Land at Gosford

Technical Note 10: Response to National Highways (NH) comments dated 6th April 2022 Reference 94443

3rd August 2022

| Appendix E - Traffic Flow Spreadsheet

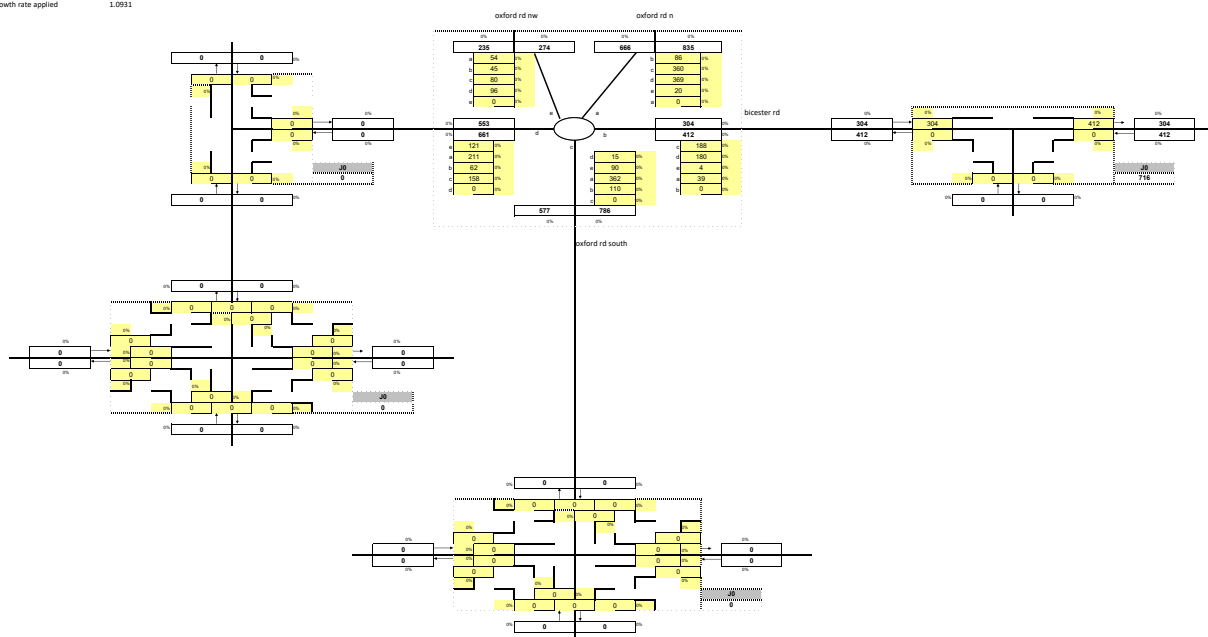
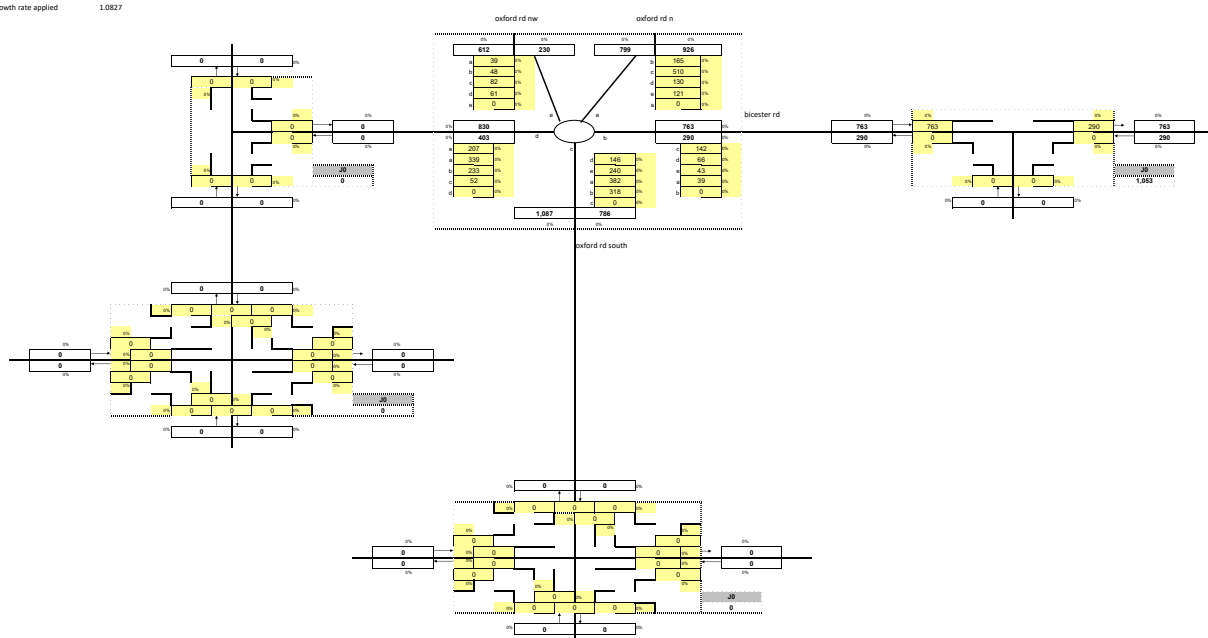
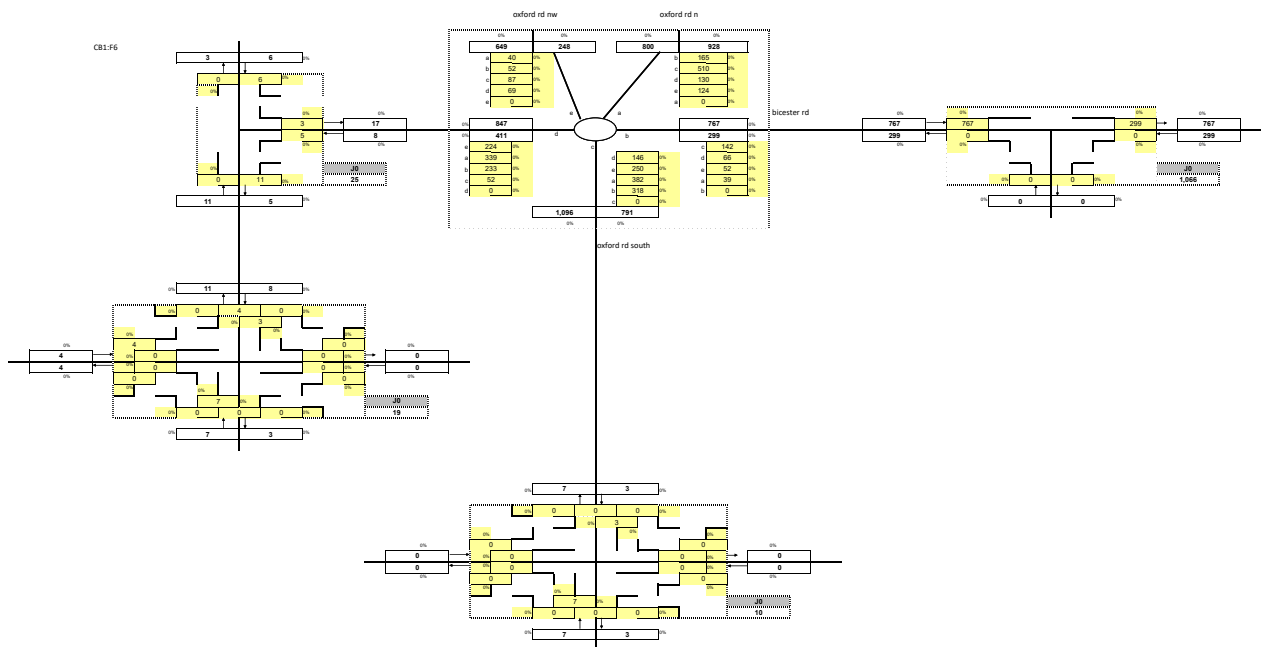
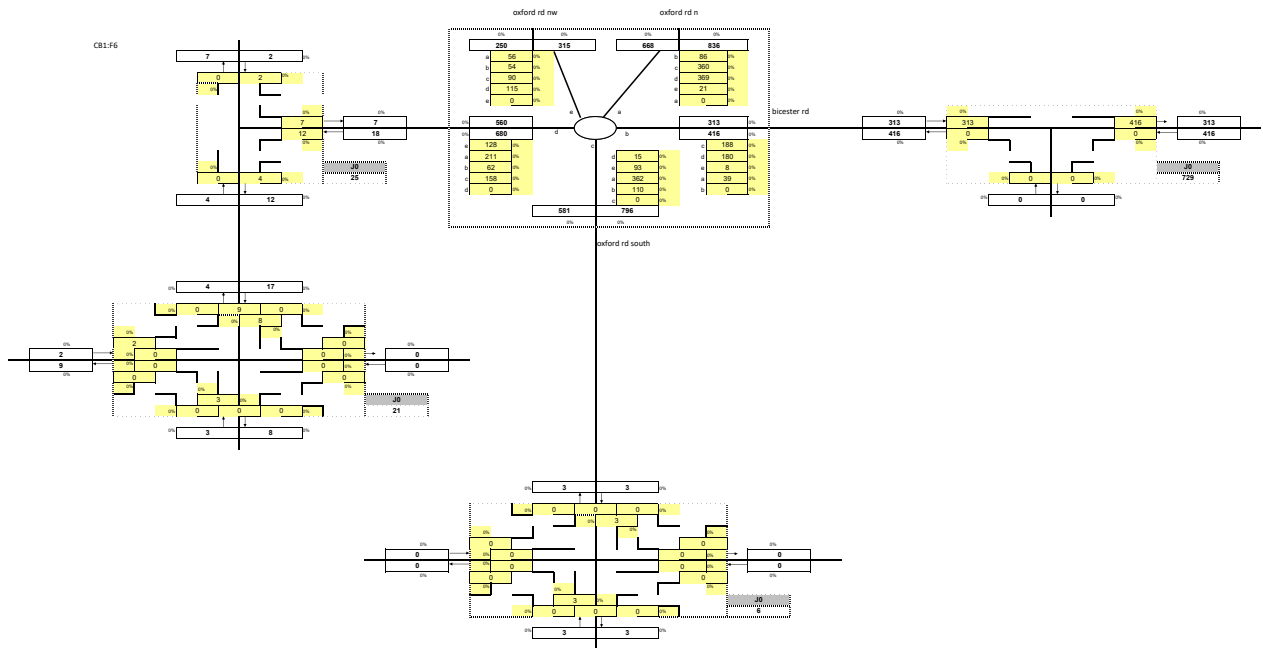
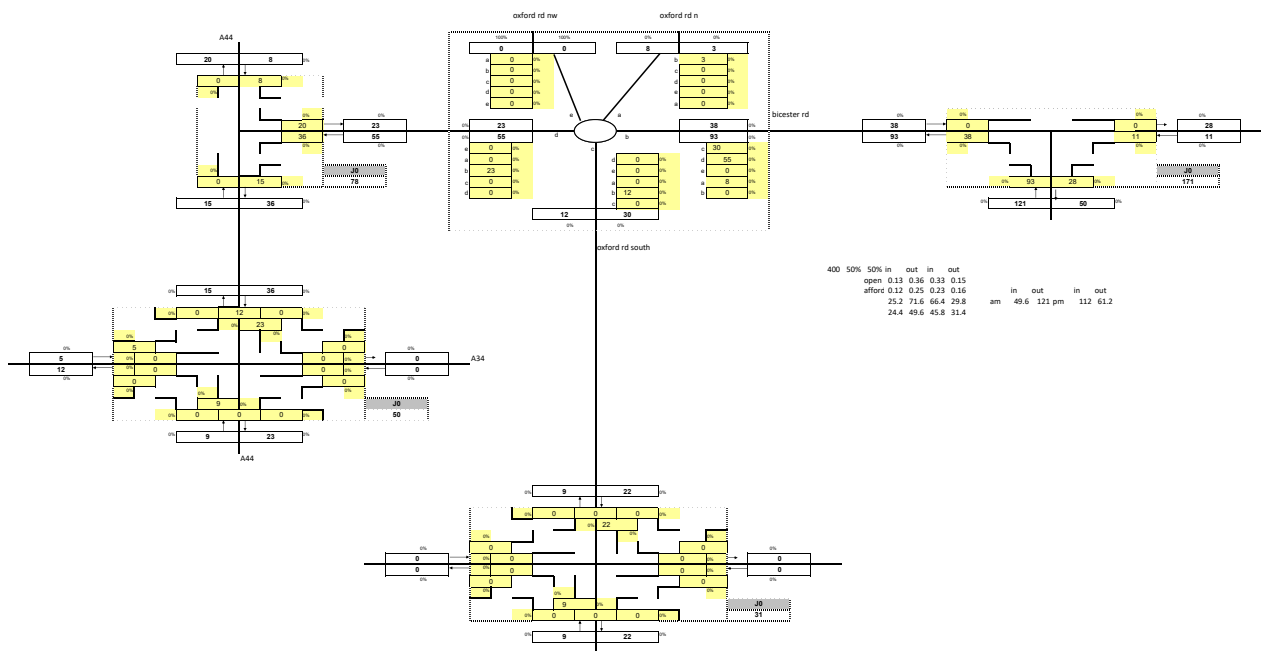
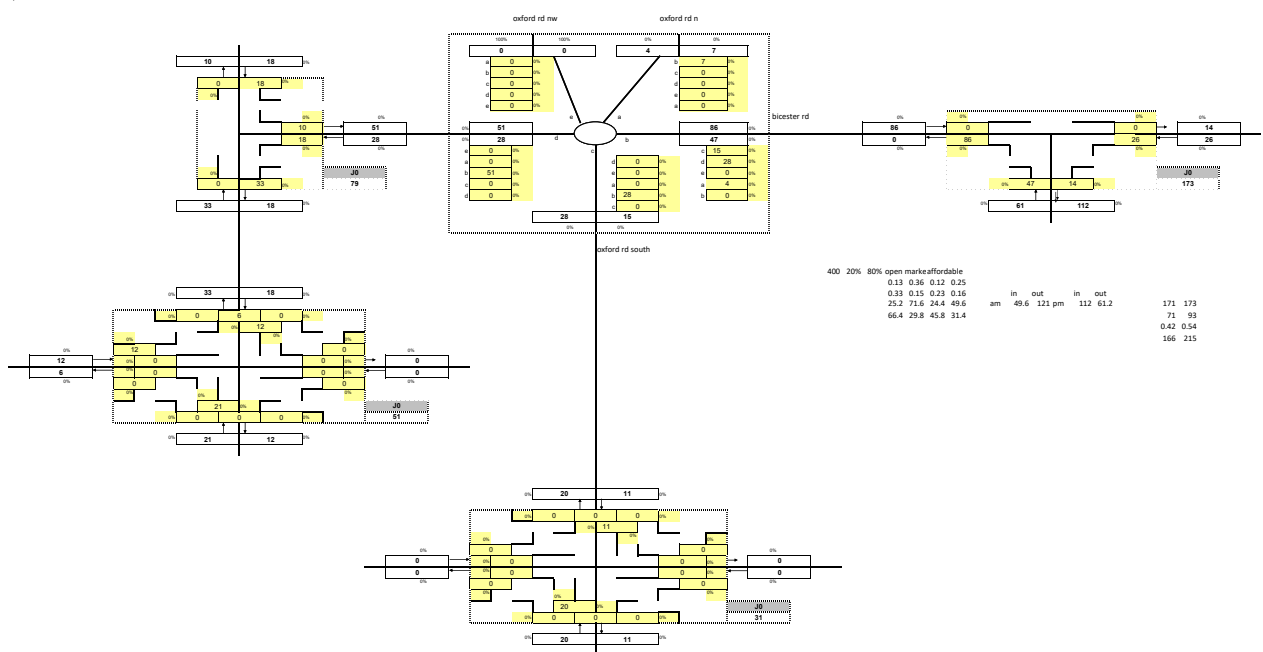
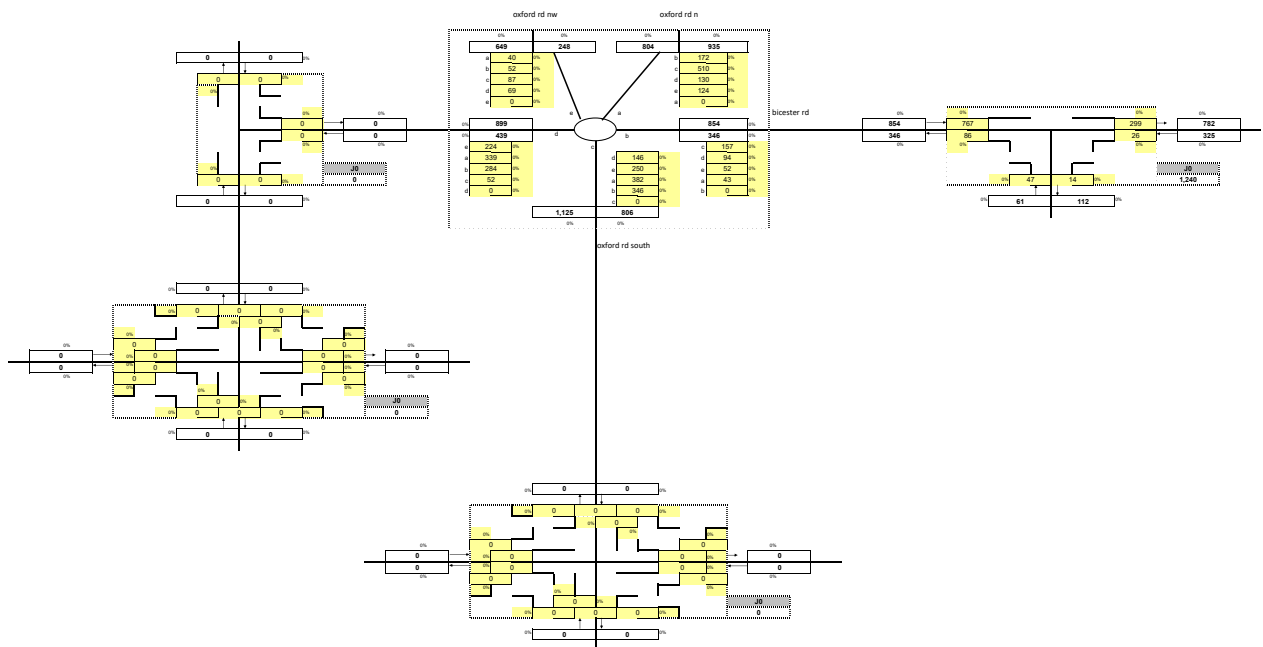
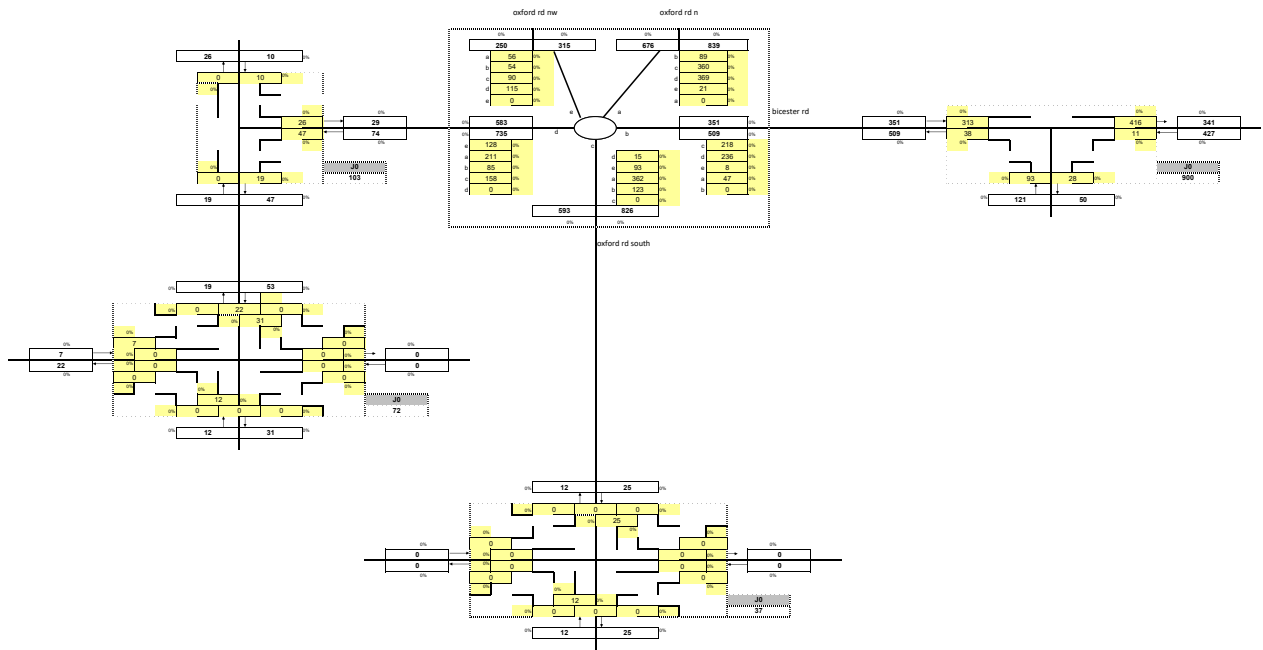
Clarification of Trip Distribution: Appendix E in the Transport Assessment is incomplete and appears to be inconsistent within itself. It also does not appear to match Table 7 - 1 in the main section of the same document.

- 3.2 On checking the appendices on the first submission it would appear that there was an omission in the figures in the appendices. For consistency the new complete Appendix E is attached to the end of this note. When considering the complete information in Appendix E in relation to Table 7-1 within the submitted TA, the figures now match. We have noted one minor error, in terms of the model For Oxford Road south, the Evening Peak data is 42 but is shown in the Table 7-1 as 43. This has been corrected, but in terms of outcome it has a non material effect.
